From: Martin Farrer <[REDACTED]>
Sent: 19 August 2019 12:29
To: Andrew Wood <Andrew.Wood@arun.gov.uk>
Cc: Ben Davies <[REDACTED]>
Subject: FW: Orkeny boats site - F/13/19/PL

DRAWING NUMBER
3186_EX_03

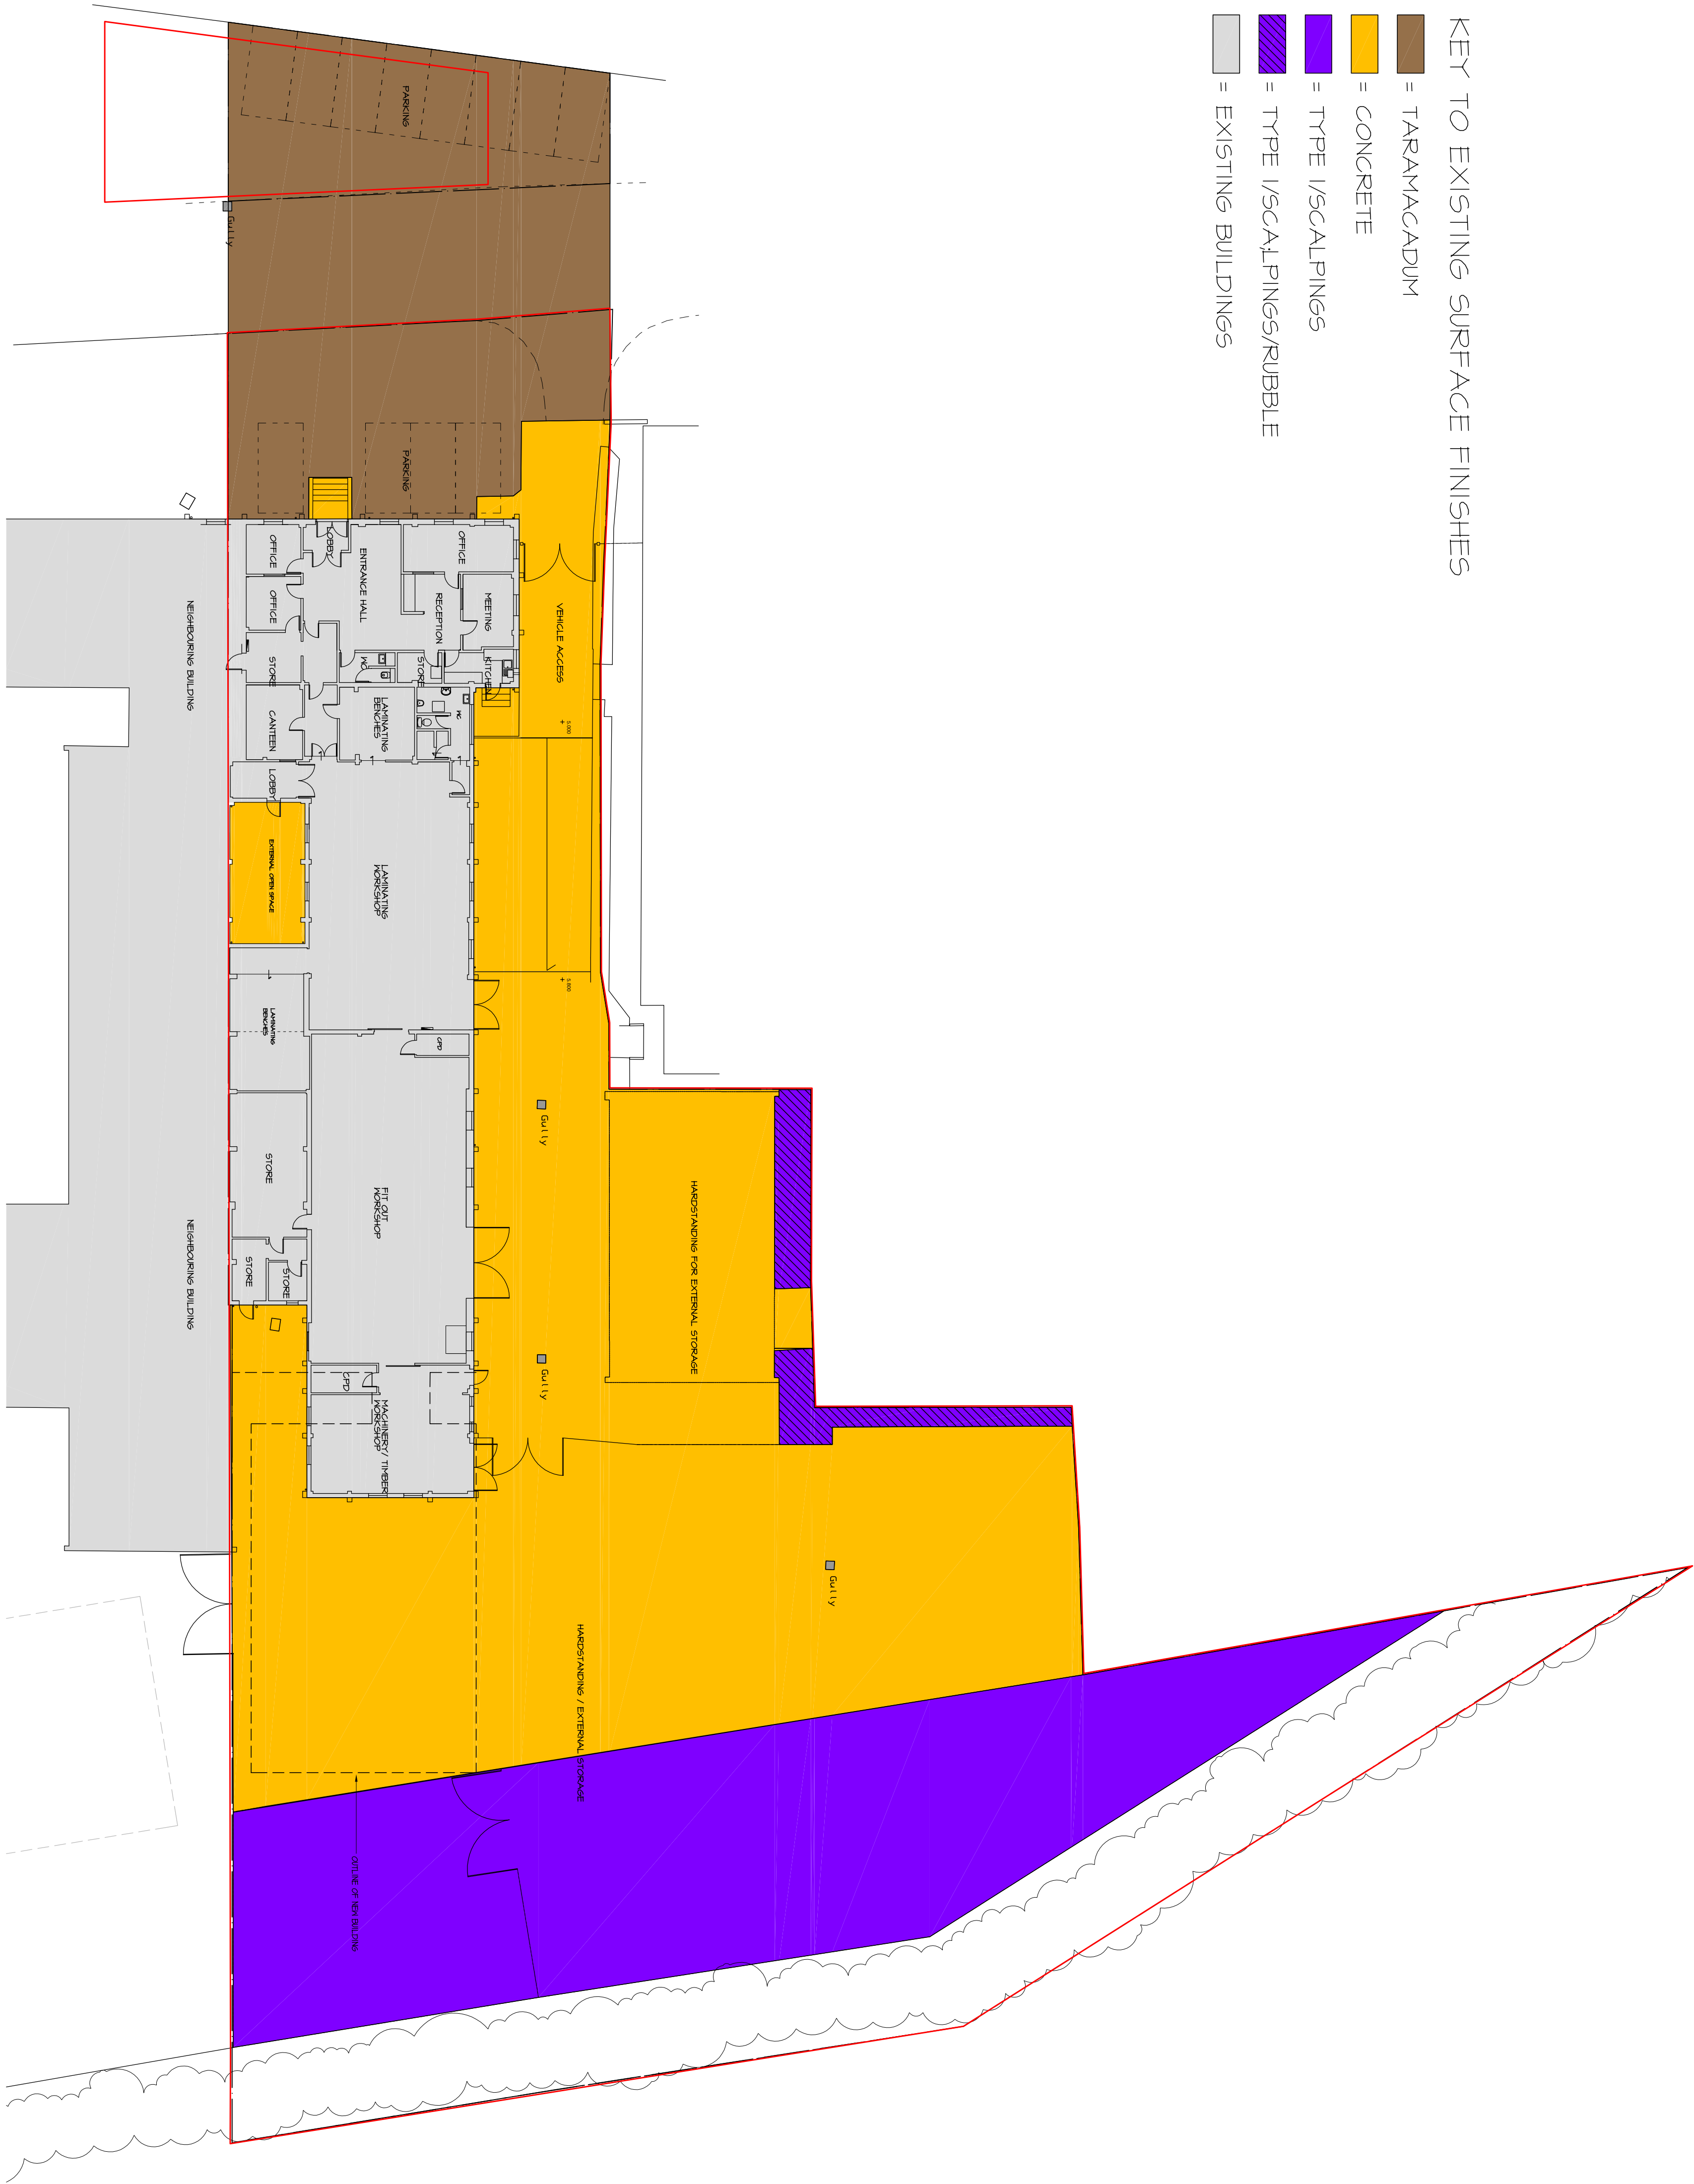
Please submit this formally to planning. If you can please also provide details of the proposed retaining wall including drainage arrangement, i.e. weep holes.

Further to our discussion yesterday, I attach landscape plan showing the existing hardsurfacing on and within the Orkney Boats site along with existing yard gullies. As you can see the whole of the site and land is covered with non-permeable surfaces, albeit buildings or hard surfacing. The proposal is to build over existing building and hard surfacing areas. The proposal for the northern retaining wall section is to make the current space along the boundary more useable as currently the ground is uneven and not suitable for hardstanding of manufactured boats or trailers etc.

I have shown existing gullies but is unclear where drainage runs to apart from belief there are soakaways on the site. The neighbouring site to the south had a scheme for drainage with soakaways with an overflow directing water to a ditch along the eastern boundary which links to the larger ditch/drain bordering the road to the south. There is a consent to link into this system if deemed required.

Details of the proposed retaining wall are included within the attached plan, as previously submitted with the application. There are no proposals for weep holes to the retaining wall structure, as believed unnecessary due to

minimal heights to the wall. The proposal therefore is for the new scalping level to be equal/slightly higher than adjacent surfaces on the site allowing for any water run-off to minimal falls towards existing gullies and no discharge of water to the adjacent land.

If this is submitted and is acceptable I will remove my request for conditions as you will be constructing over an impermeable area that is positively drained.
